File No: NTH18/00047
Your Ref: SSD 9575

Tweed Coast Road (MR450): SSD 9575 Notice of Exhibition, Tweed Valley Hospital, Cudgen Road, Cudgen

I refer to your letter of 29 October 2018 requesting comment from Roads and Maritime Services in relation to the above mentioned State Significant Development.

Drawing Title
**GENERAL ARRANGEMENT
AND KEY PLAN**

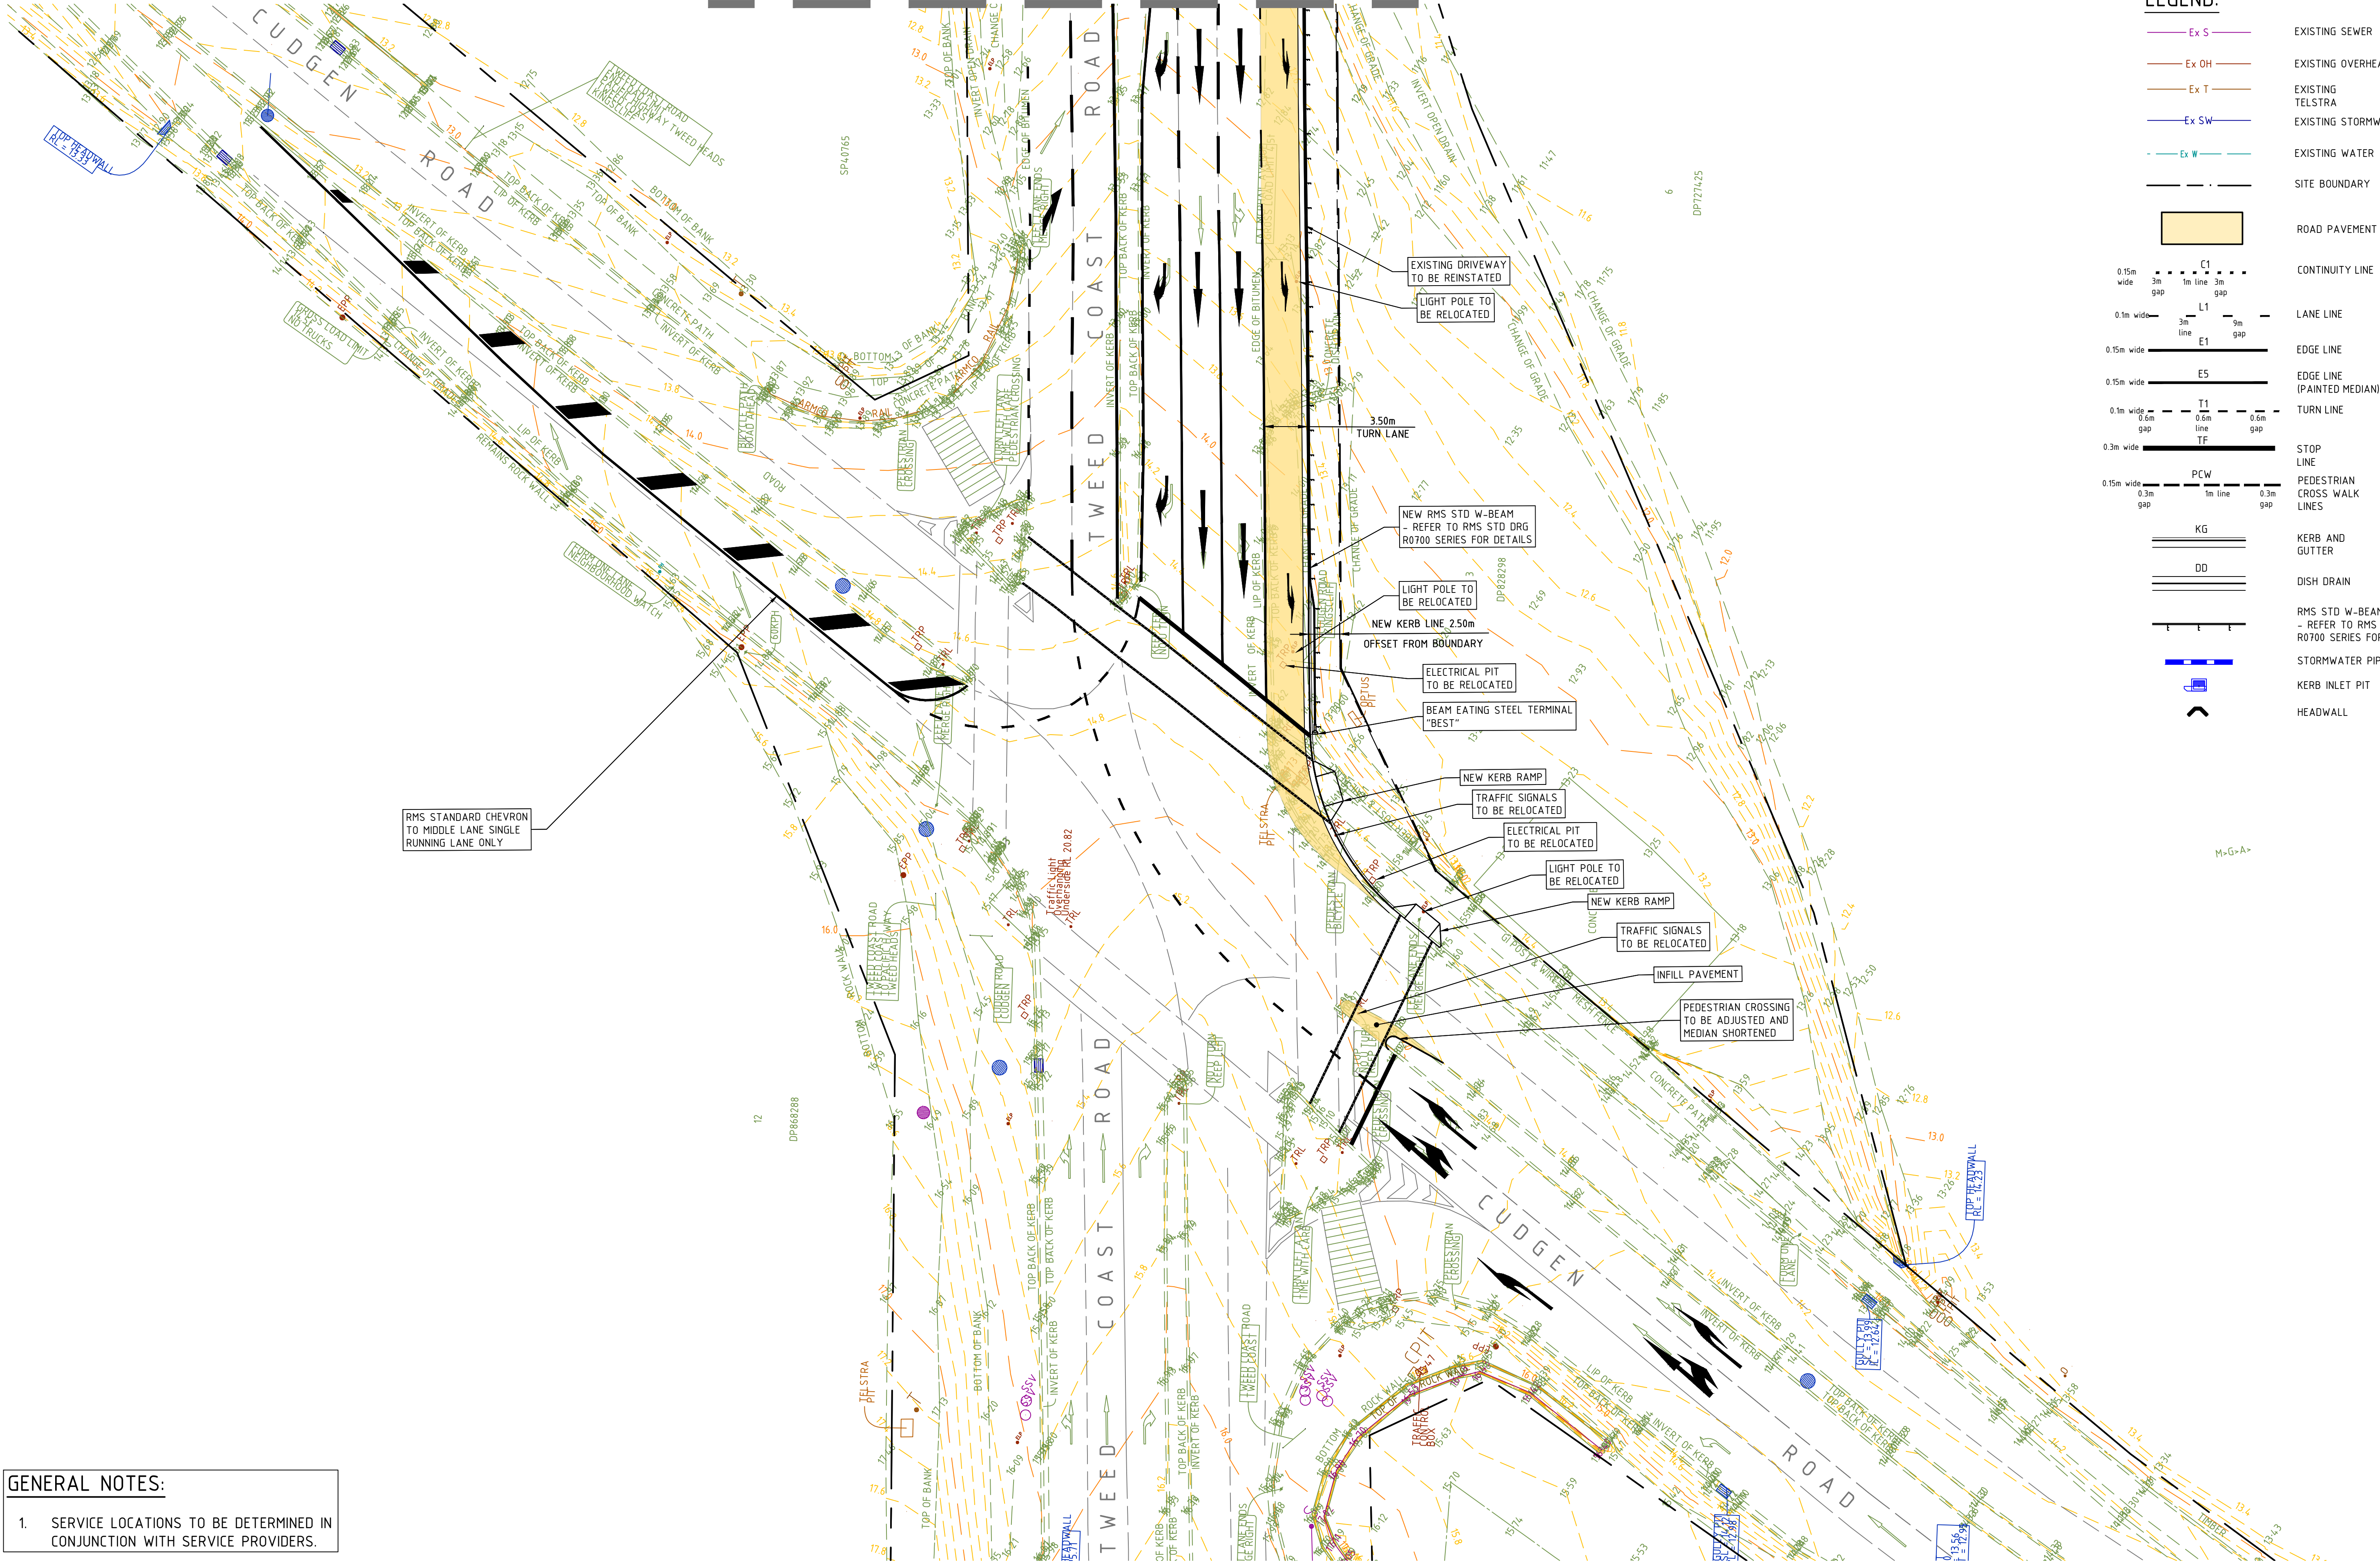
- Clarification of the Tweed Valley Hospital scope of upgrade works for Tweed Coast Road / Cudgen Road intersection upgrade.
- Council were advised that the traffic signal infrastructure works will require the Developer to enter into a Works Authorisation Deed (WAD) with Roads and Maritime.
- Council confirmed planning work is in progress for the proposed duplication of Tweed Coast Road.

- The Developer shall enter into a Works Authorisation Deed (WAD) with Roads and Maritime for the traffic signal infrastructure works the local and classified road network. The Developer will be responsible for all costs associated with the works and administration for the WAD.
